Please ask for: Jonny Cooper  
Email: [jonny.cooper@arun.gov.uk](mailto:jonny.cooper@arun.gov.uk)  
Telephone: 01903 737532  
Our Ref: BR/38/25/PDH  
Your Ref:  
Date: 7th March 2025

**Prior Notification for a Permitted Development (Householder)**

**Development:** Single storey rear extension  
**Location:** 9 Lyon Street Bognor Regis PO21 1BW

PROJECT	9 Lyon Street PO21 1BW		CLIENT	Chen	
SHEET	Elevations-Right/Left side		Date	Issue Date	Scale (@ A3) 1 : 100
			Drawn by	SW	DRAWING NUMBER
			Checked by	SR	P 4
					REV

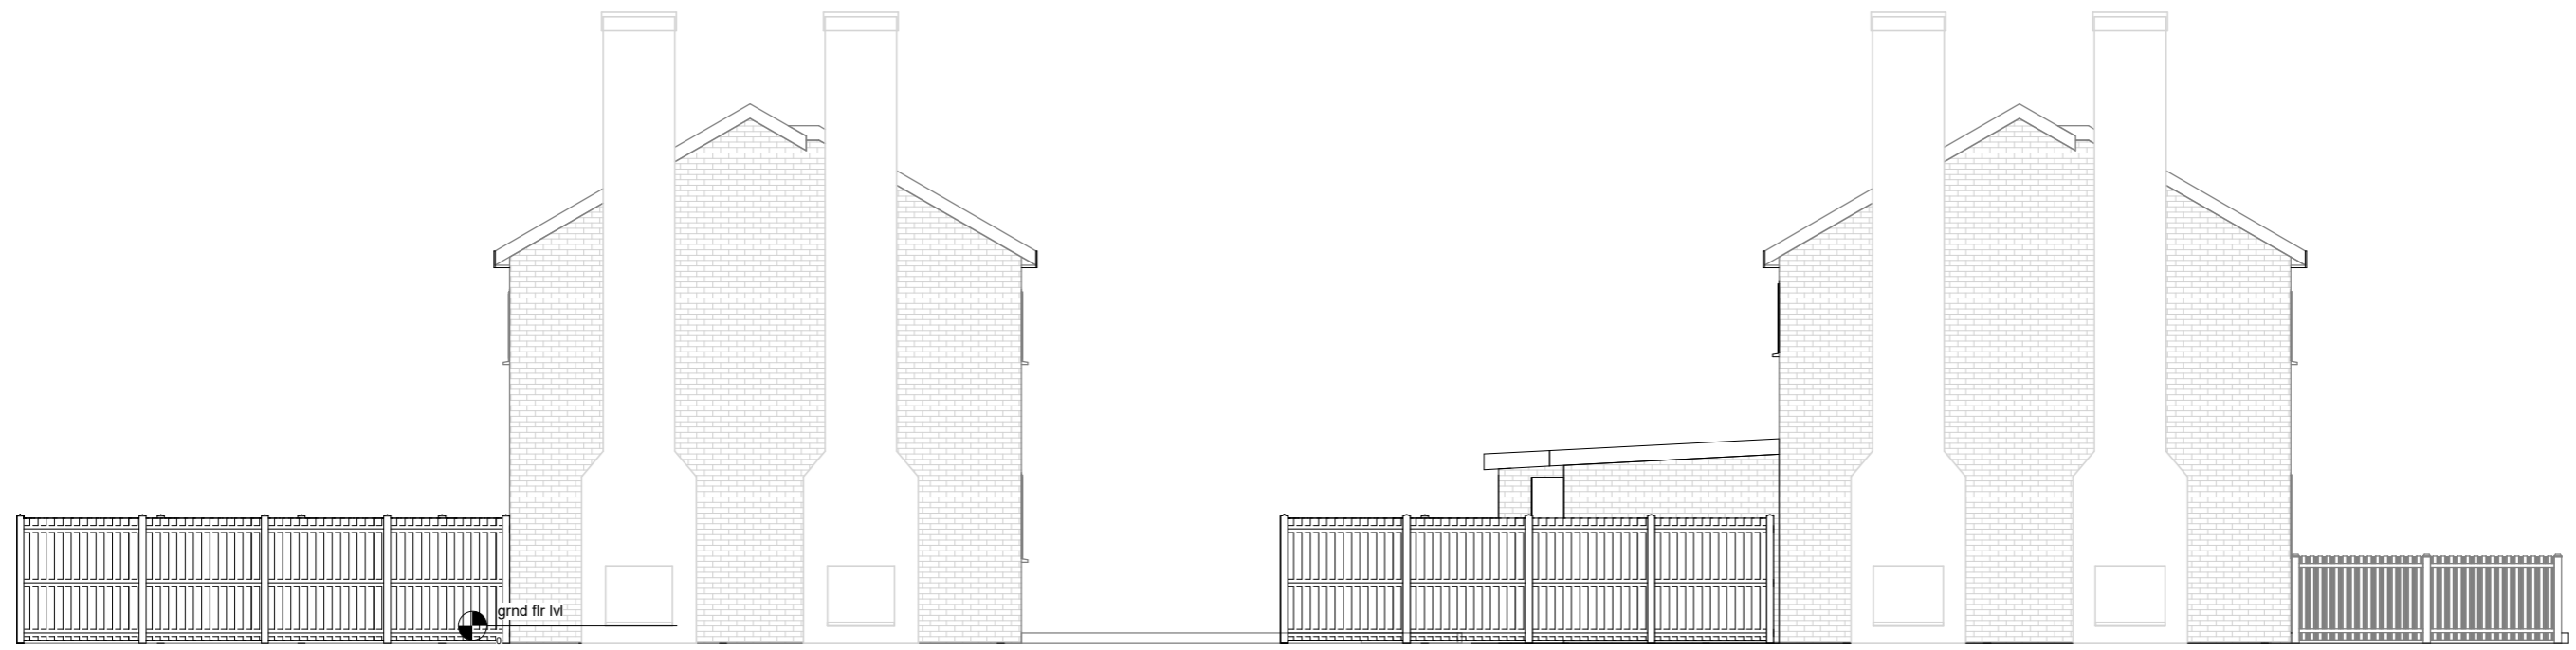
Your application proposes changes to fenestrations at first floor and ground floor level which are not part of the proposed rear extension. Only the rear extension can be considered within this part of the act. Please either amend your plans to include only the rear extension or withdraw this application.
